The Ship Inn, 7 Deveronside, Banff, AB45 1HP
Proposed Listed Building Consent for Extension, External and Internal Alternations to Form Self Catering Accommodation
Planning Ref No: APP/2023/2289

We refer to the letter of 12 December 2023 from Fenella Mcleay and attach herewith copies of Drawing Nos. 23065 04B, showing amended proposals for the above.

Roof Plan 1:100

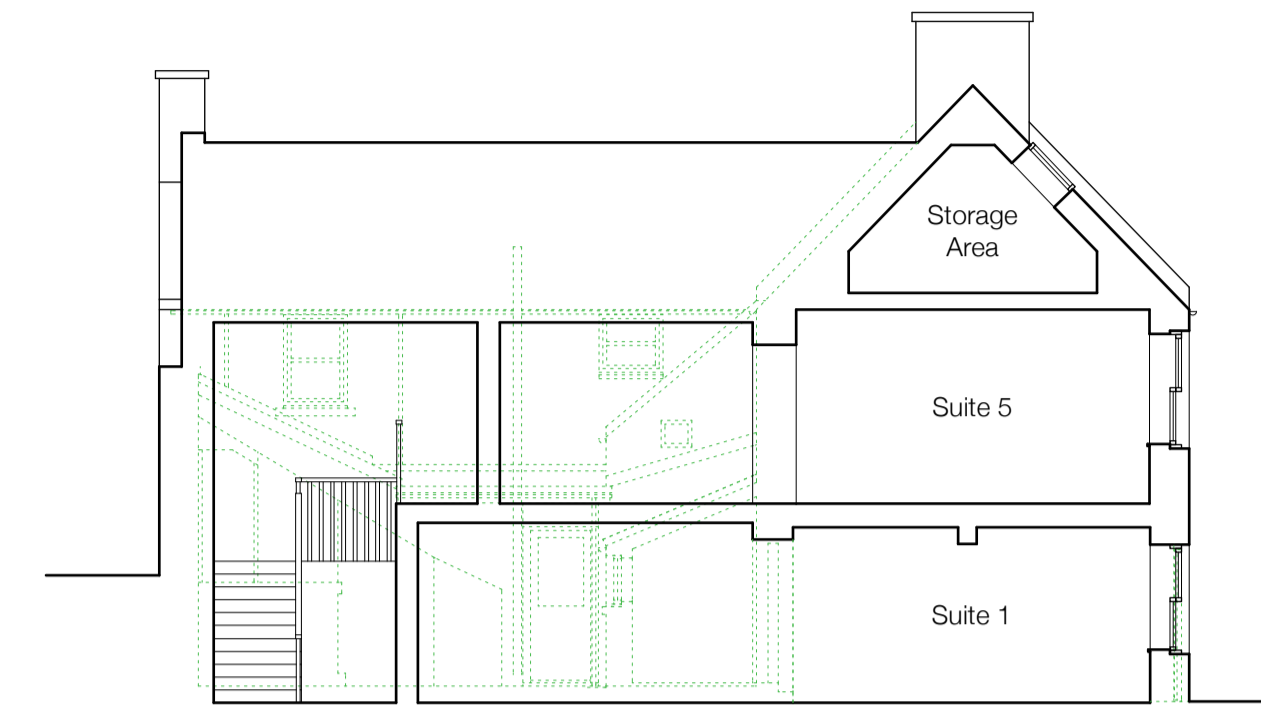
1. We have added a sectional West elevation.
2. We have added a sectional South elevation.
3. We have added a roof plan.
